Our ref: RA/2025/149024/01-L01
Your ref: 2025/92728
Date: 17 December 2025

**ERECTION OF 33 DWELLINGS WITH ASSOCIATED CAR PARKING AND
LANDSCAPING
LAND AT, DOWKER STREET, MILNSBRIDGE, HUDDERSFIELD, HD3 4JU**

Environment Agency position

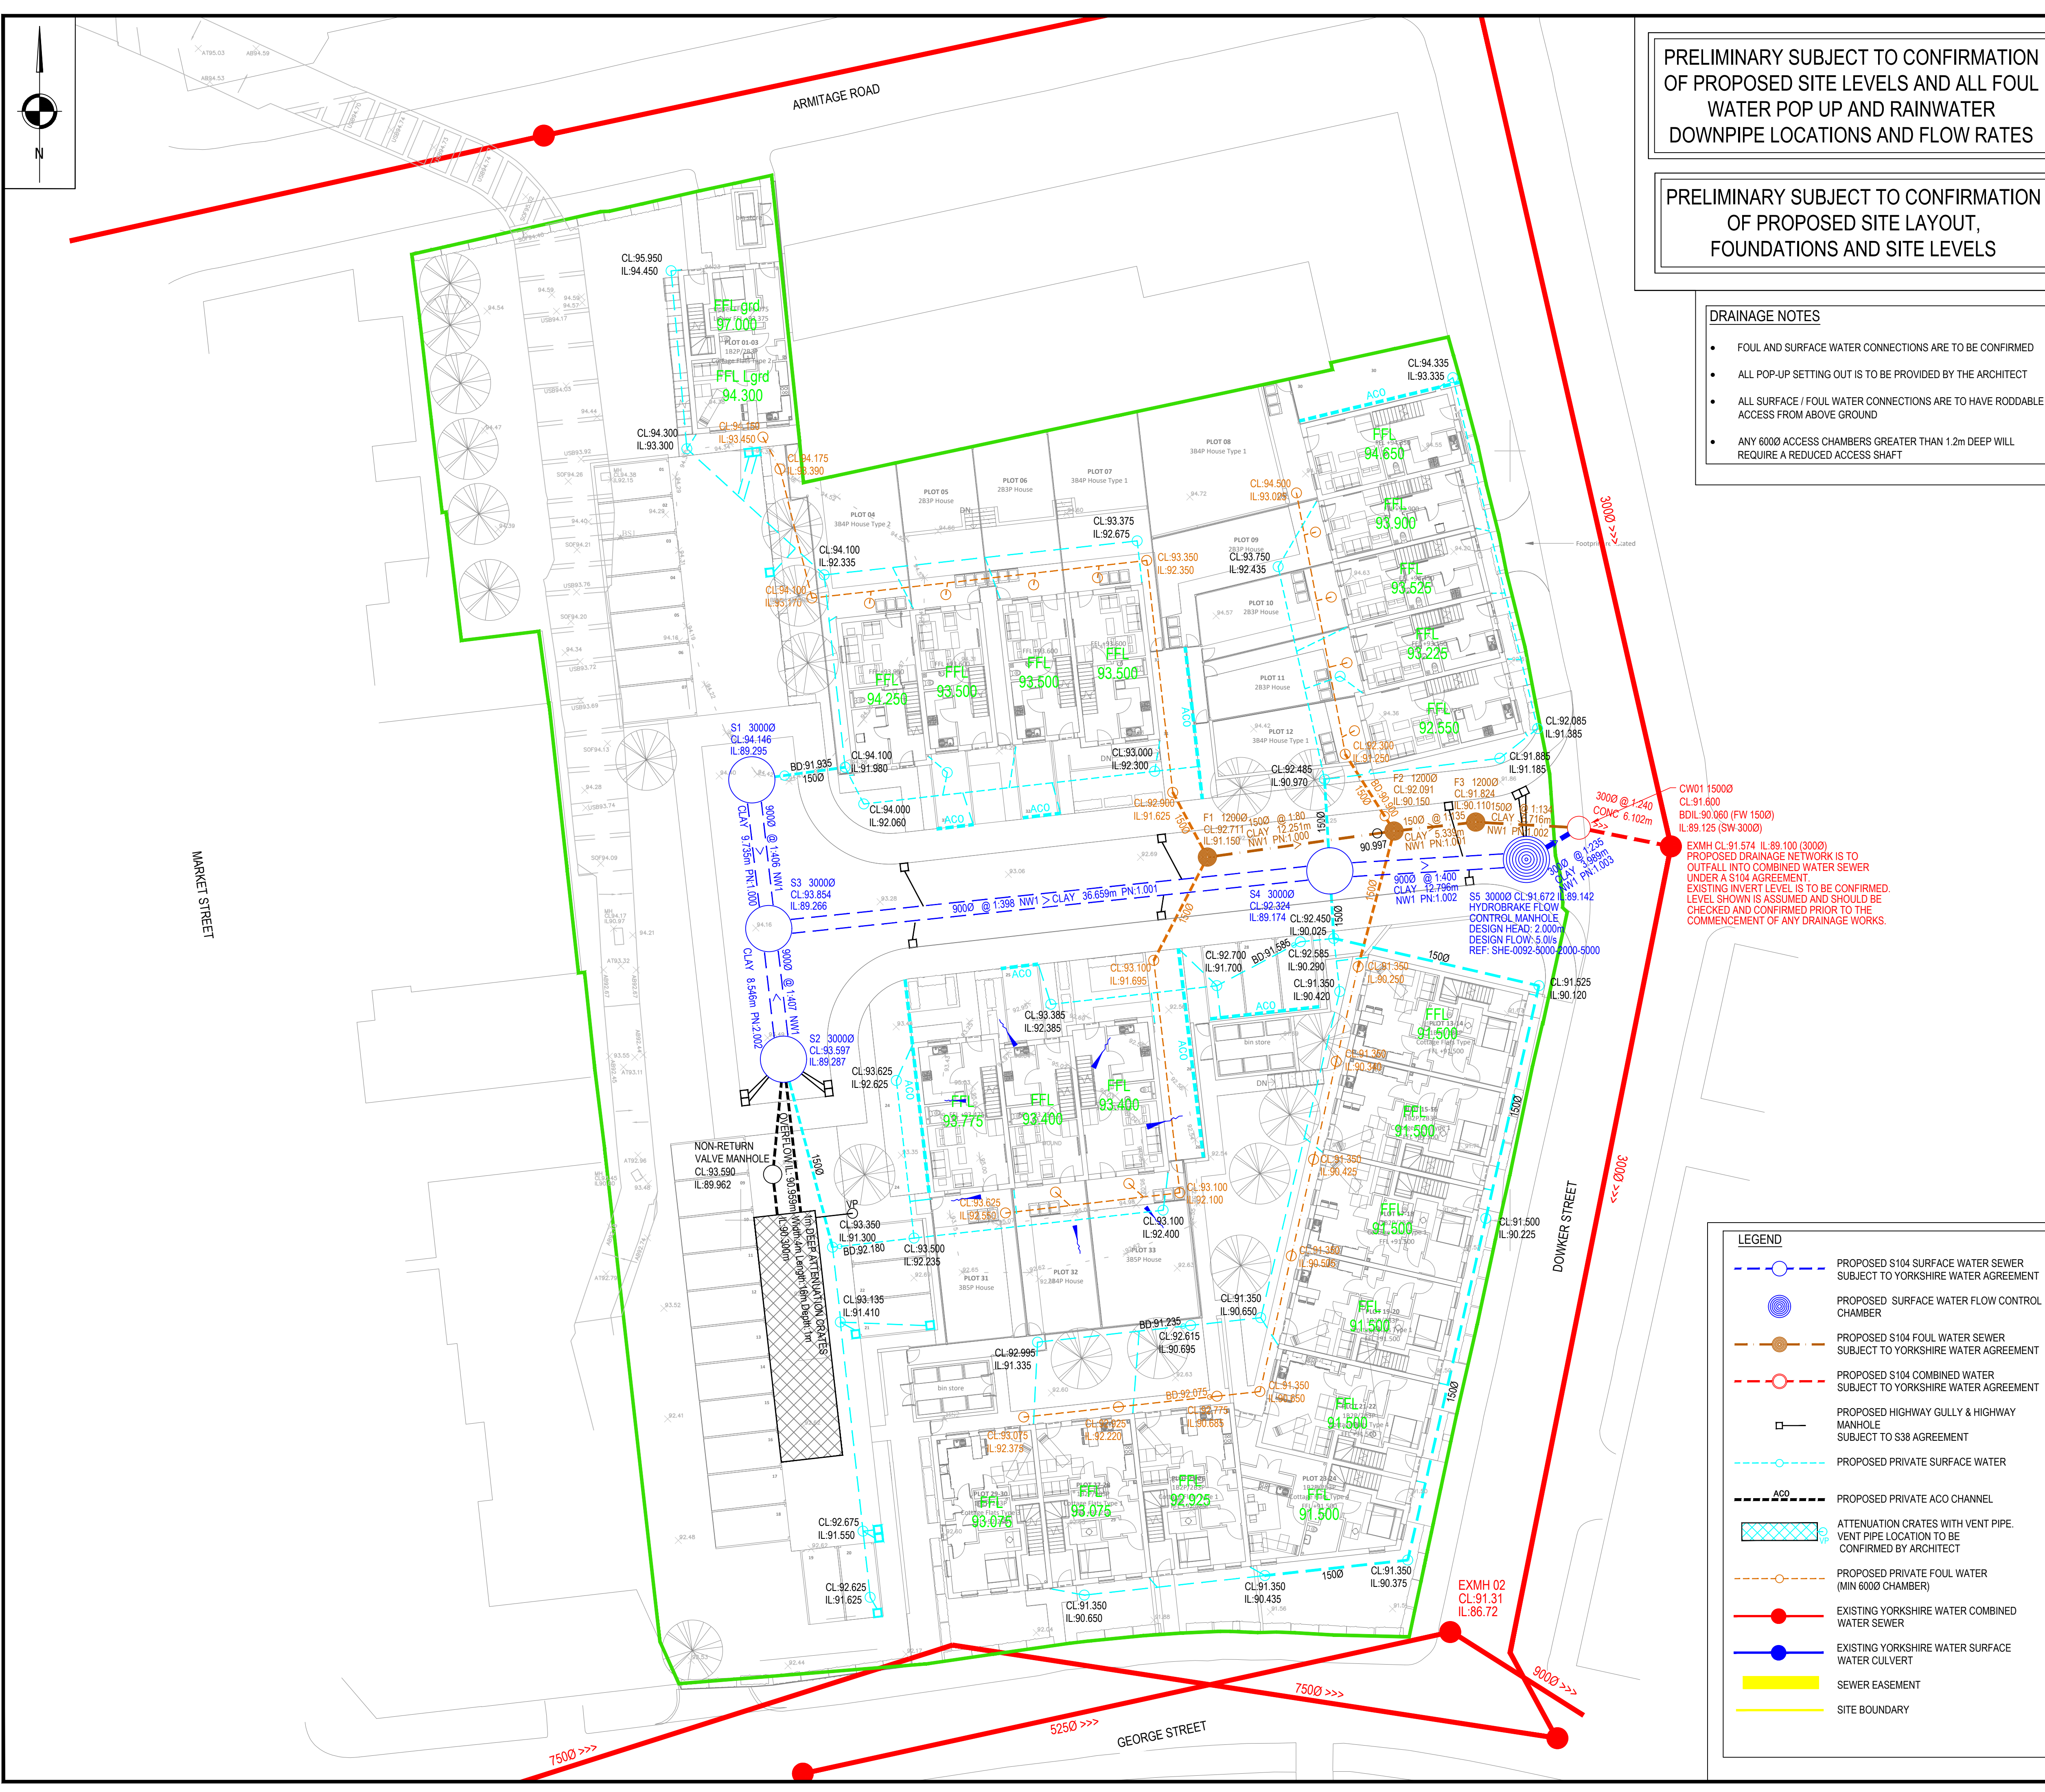
We object to this application as it involves building over and works within 8 metres of a watercourse. As submitted, it is unlikely that we would grant a flood risk activity permit for this application.

The proposed development would restrict maintenance and emergency access to the watercourse. The permanent retention of a continuous unobstructed area is an essential requirement for future maintenance and/or improvement works.

We note that the easement for the culvert has been measured from the centre line of the culvert. The easement should be measured from the outer edge of the culvert. We note that Plot 01-03 is on the edge of the easement measured from the centre of the culvert, it is therefore highly likely that the Plot will be within the required easement when measured from the outer edge of the culvert. We also note that the proposed development involves locating car parking over the culvert.

The applicant should rearrange the site so that there is no development within 8m or 45 degrees from the outer edge of the culvert, including car parking.

Flood mitigation around culverts should consider what would happen if the culvert collapses. Consideration should also be given to the maintenance of the culvert and if there are opportunities to deculvert the watercourse.
